One Earth Solar Farm

Draft Statement of Common Ground with Bassetlaw District Council

EN010159/APP/8.5.1

August 2025

Figure 11.1: Site Location and Study Area

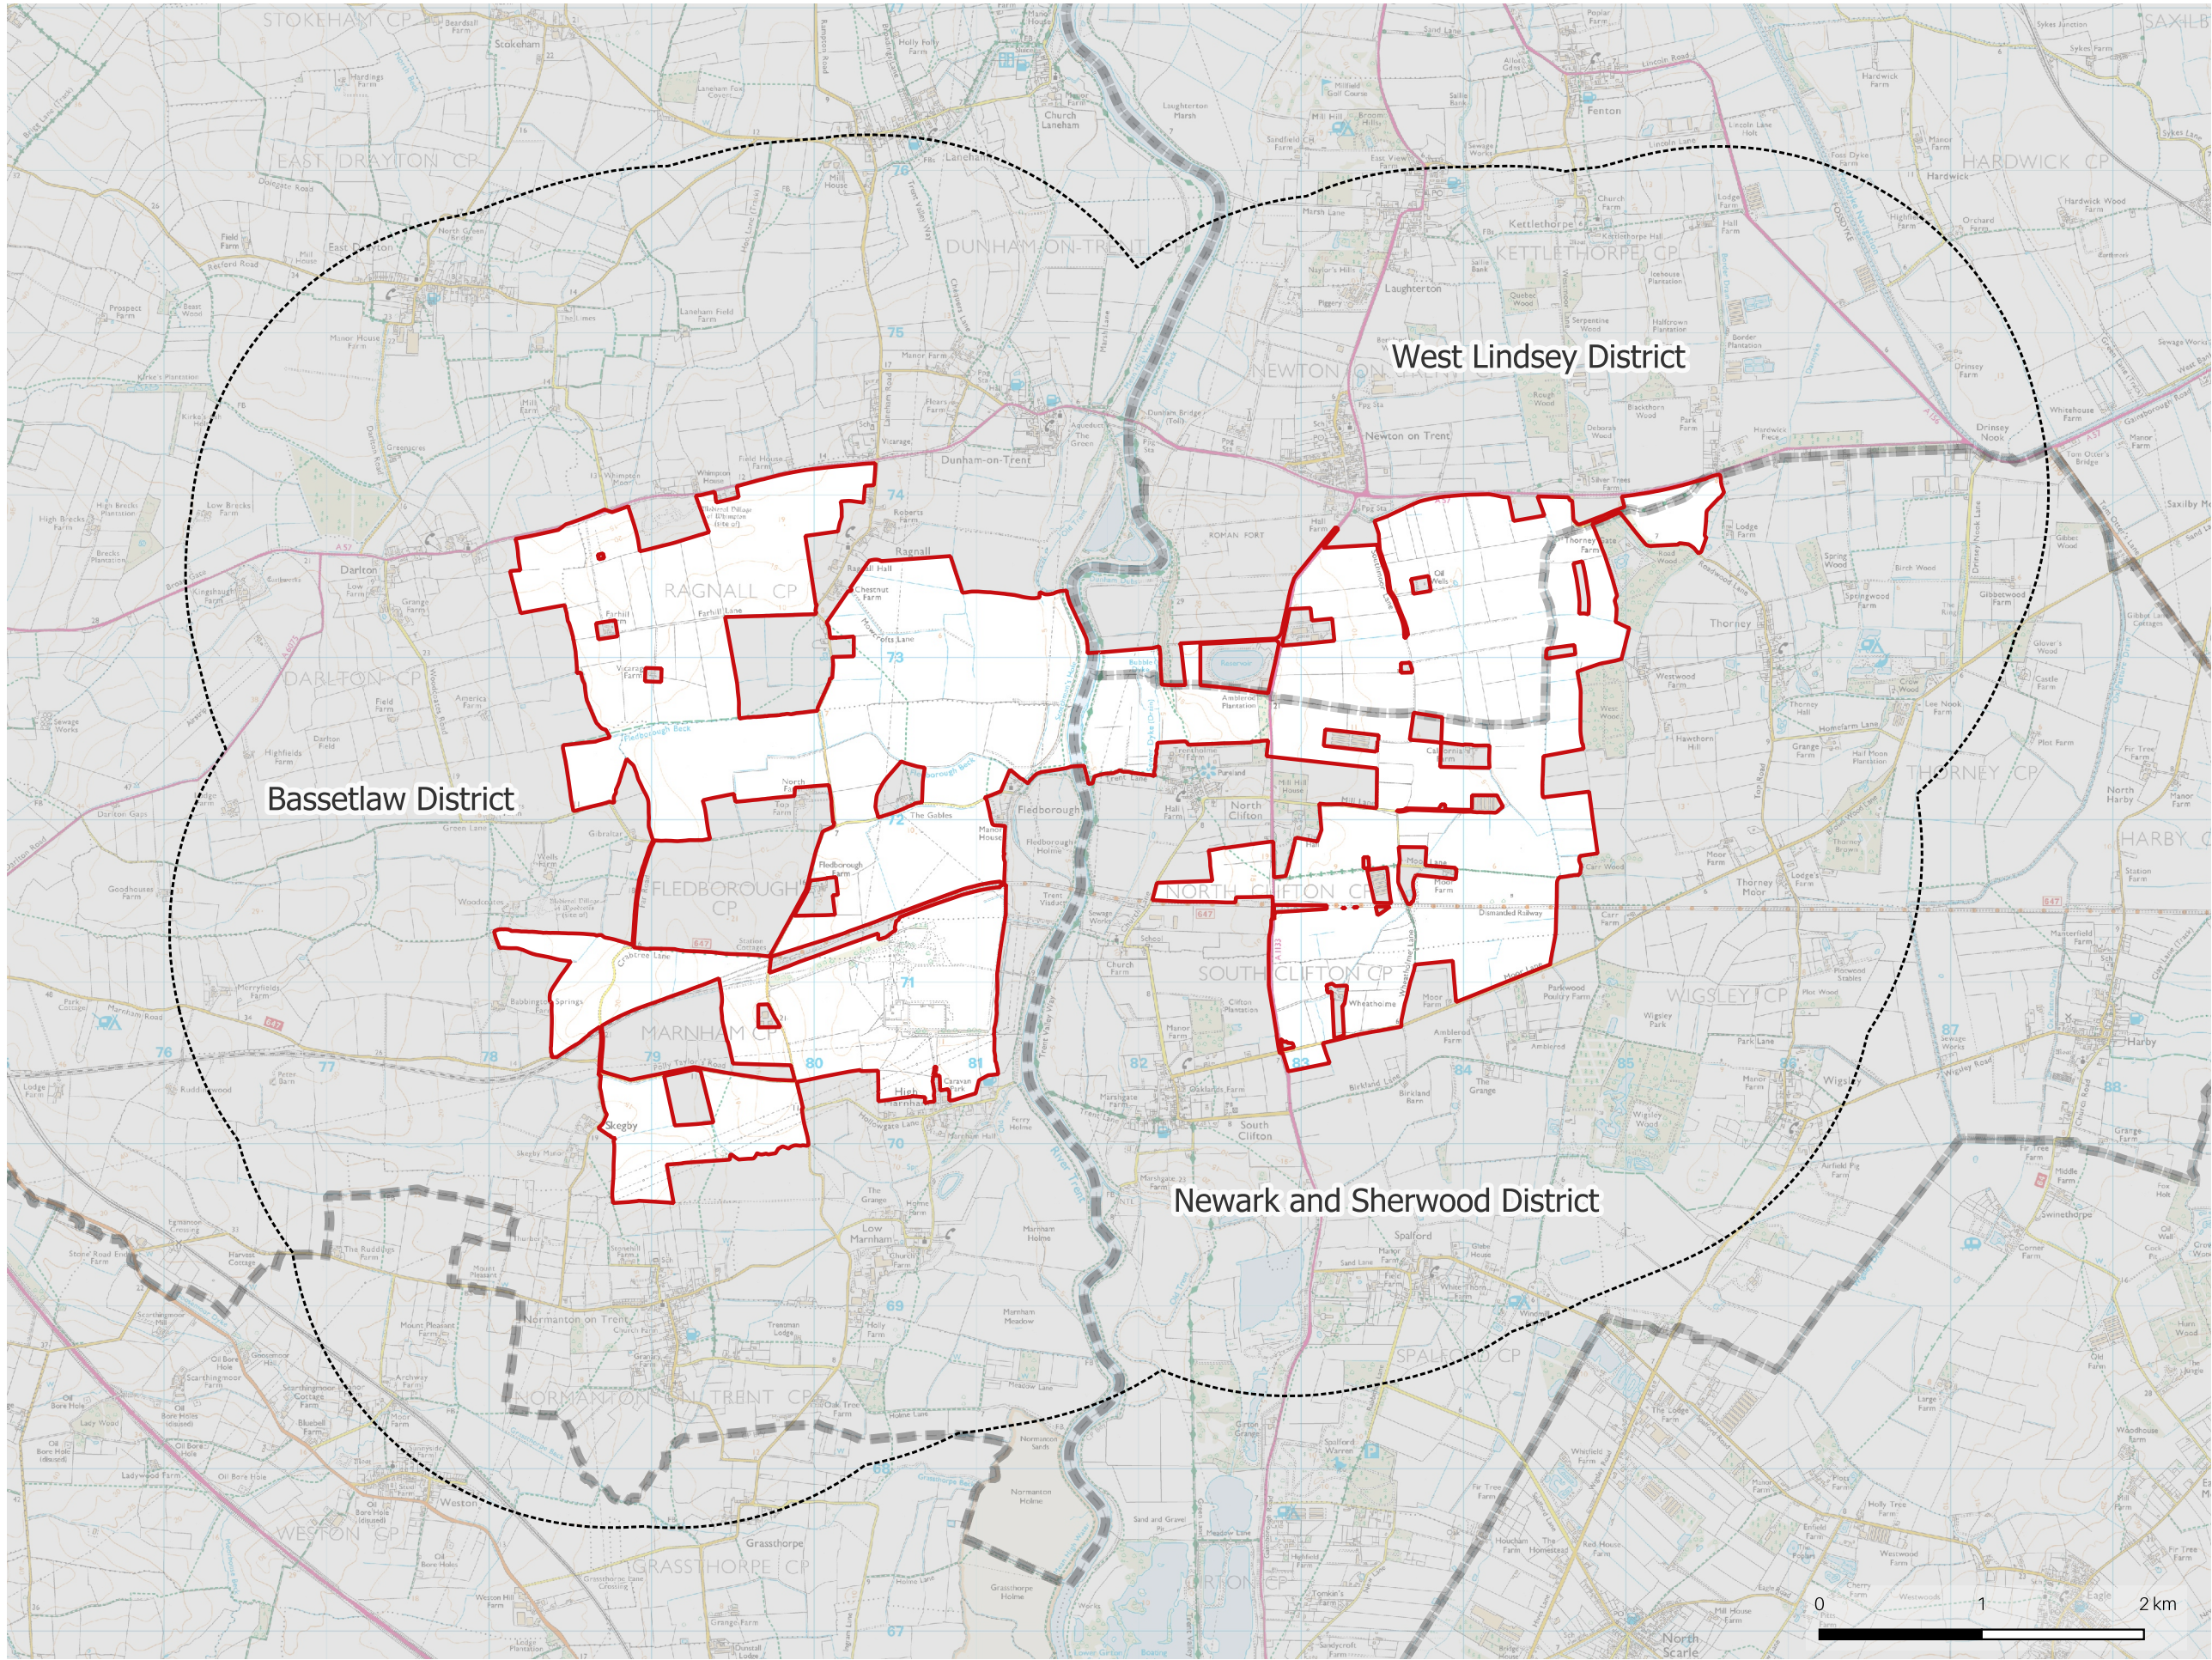
06-02	LVIA Study Area	<p>AAH Consultants commented that effects beyond 2km had not been considered fully at the PEIR as all the proposed viewpoints were located within the 2km LVIA Study Area, despite the ZTV showing the potential for visibility beyond 2km.</p> <p>In response, photographs from 8 locations were provided by the applicant to test the judgement of no significant visibility beyond 2km.</p> <p>AAH Consultants welcomed these photographs but questioned the location of some of them in terms of representativeness of the receptor.</p>	<p>The LVIA 2km Study Area is agreed following a site visit between the applicant and AAH Consultants on 25th June 2025 which included visiting several of the locations of the supplementary photographs previously provided, confirming that they are representative.</p>	Agreed
06-03	Scope of landscape receptors	<p>The inclusion of Thorney as a Local Village Character Area following feedback on the PEIR was welcomed.</p> <p>No further comments or concerns on the scope of landscape receptors have been raised to date.</p>	<p>The scope of landscape receptors is agreed.</p> <p>The scope of landscape receptors was updated in the LVIA ES Chapter to include for the suggested additions and refinements.</p>	Agreed

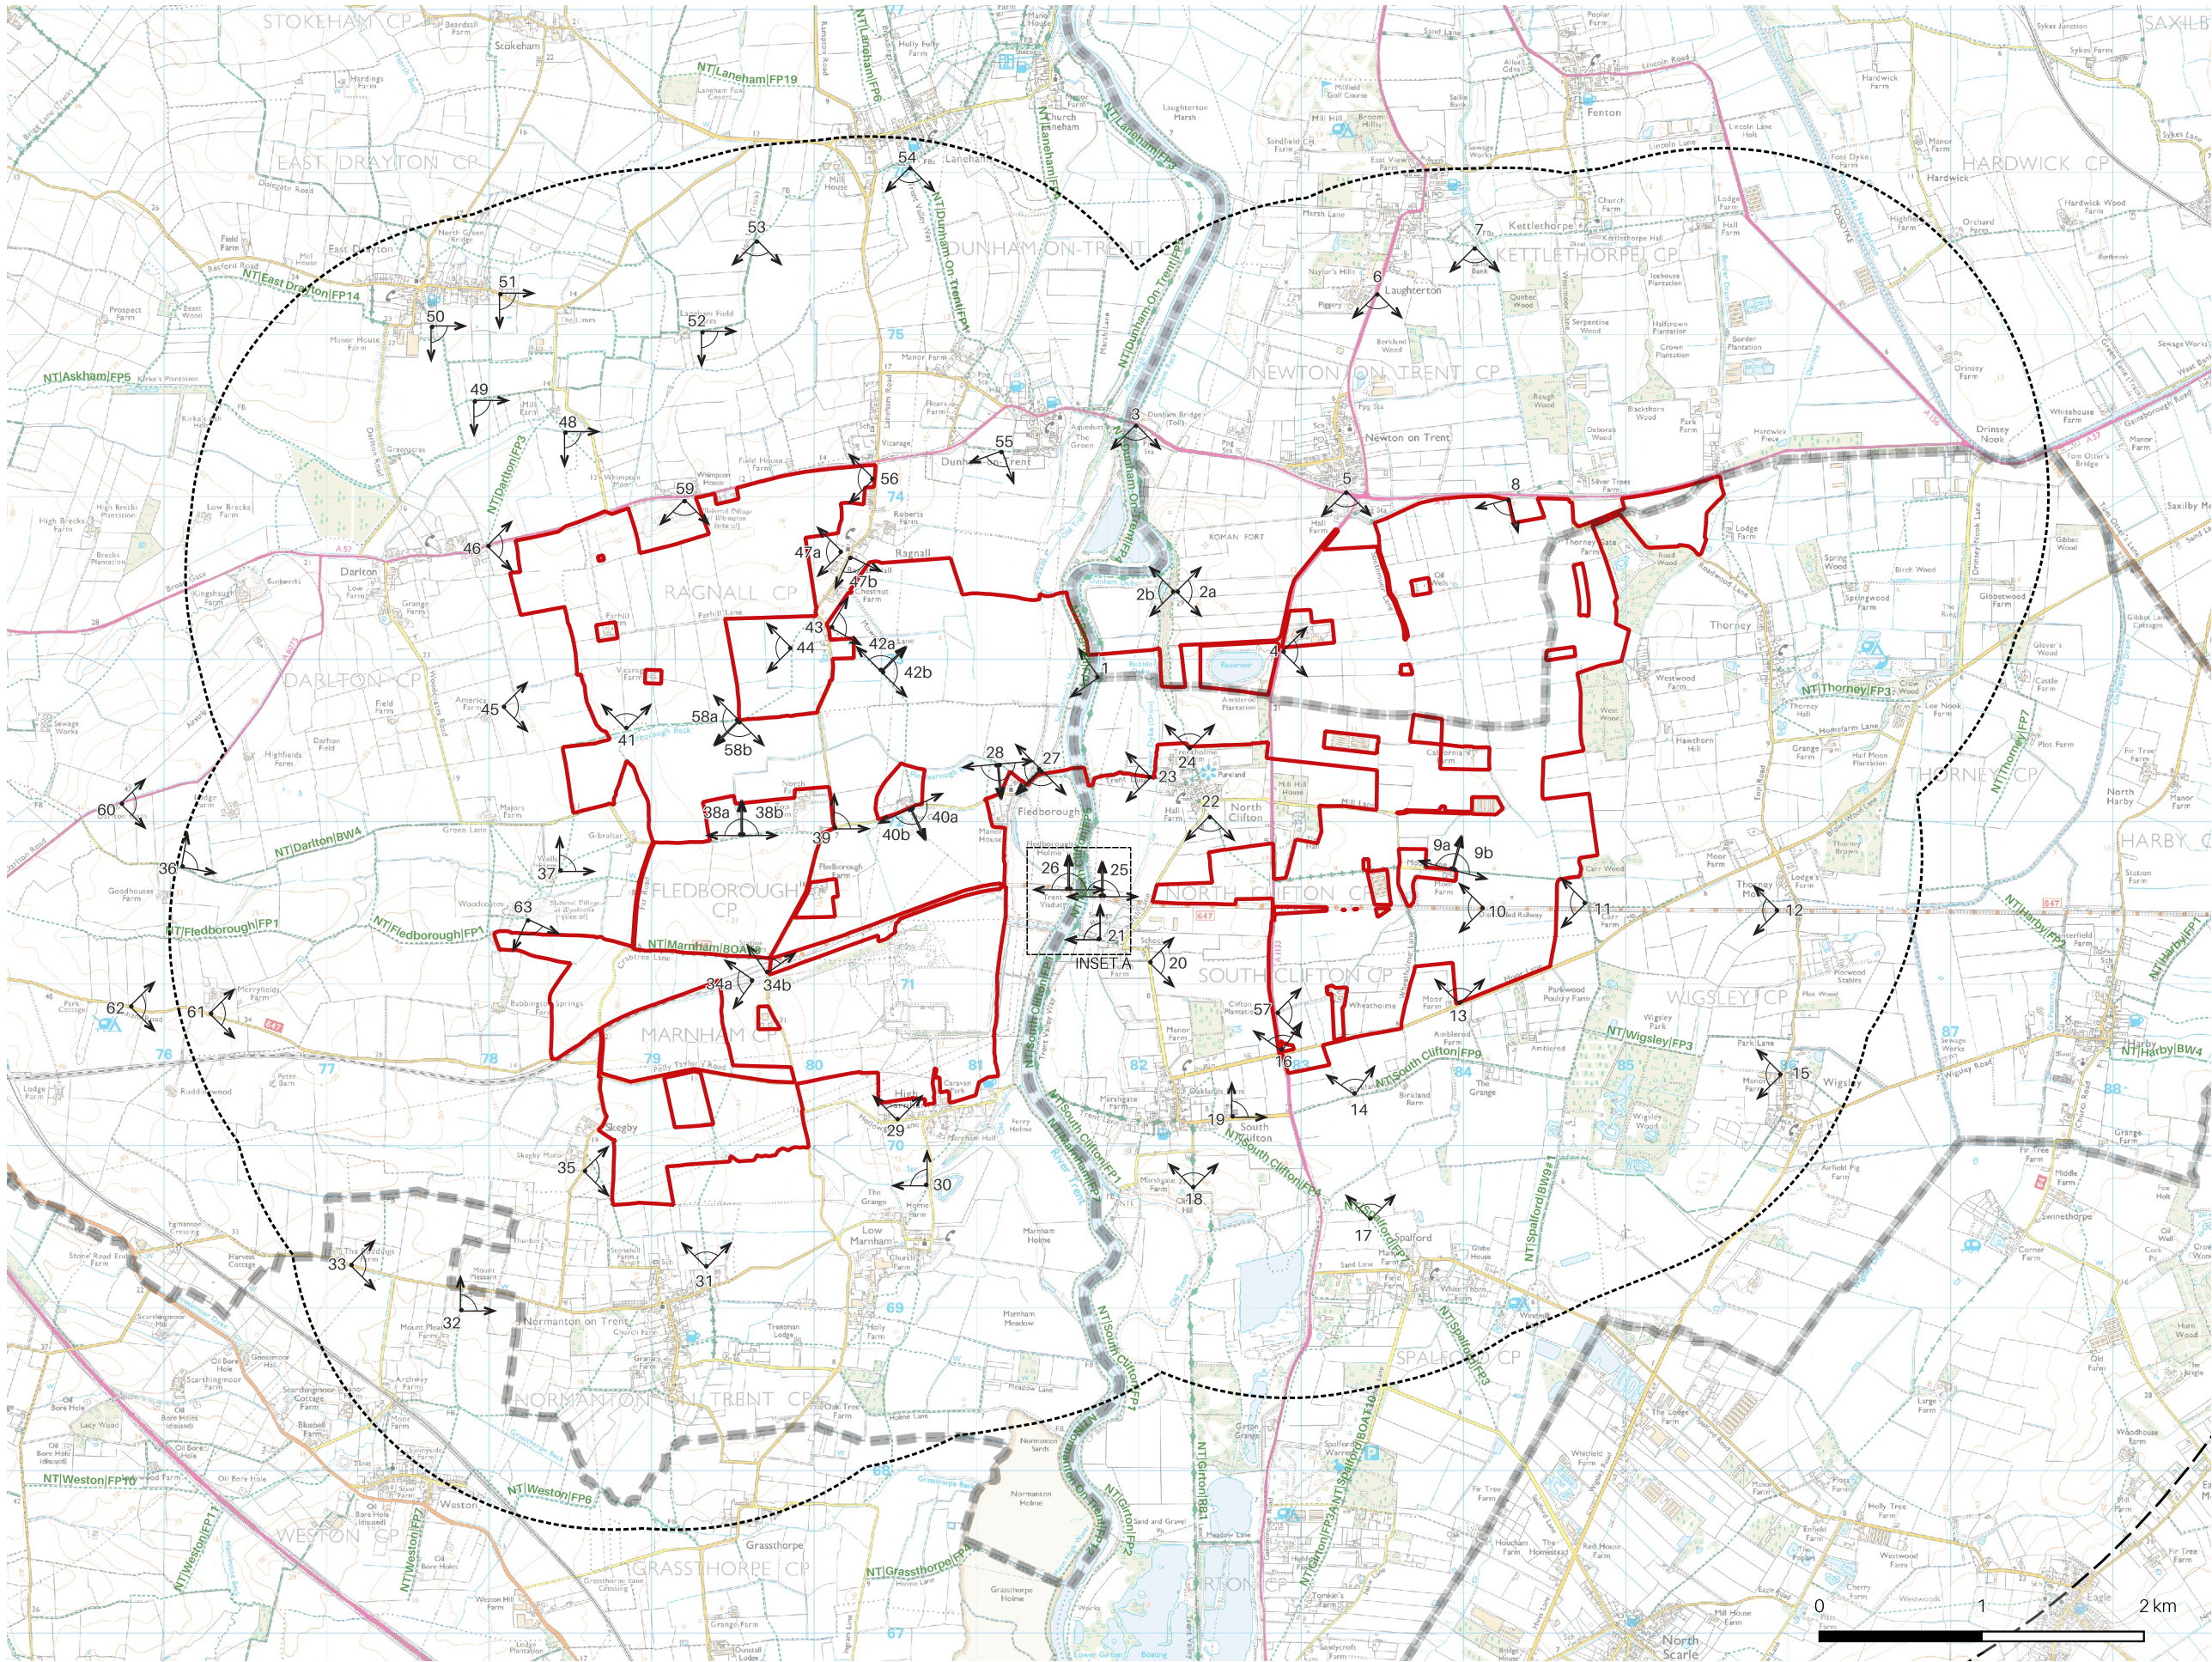
06-05	Scope of representative viewpoints	The location of some of the representative viewpoints were questioned and additional viewpoints were suggested following review of the PEIR. No further comments or concerns on the scope of representative viewpoints have been raised.	The scope of representative viewpoints is agreed. The scope of representative viewpoints was updated in the LVIA ES Chapter to include for the suggested additions and refinements.	Agreed
06-06	Scope of photomontages	An additional Type 4 photomontage was suggested from Viewpoint 58 following review of the PEIR. No further comments or concerns on the scope of representative viewpoints have been raised.	The scope of photomontages is agreed. Further discussion was had between the applicant and the District Councils during the preparation of the LVIA ES Chapter regarding the scope of photomontages resulting in agreement that the number and distribution of locations is sufficient.	Agreed
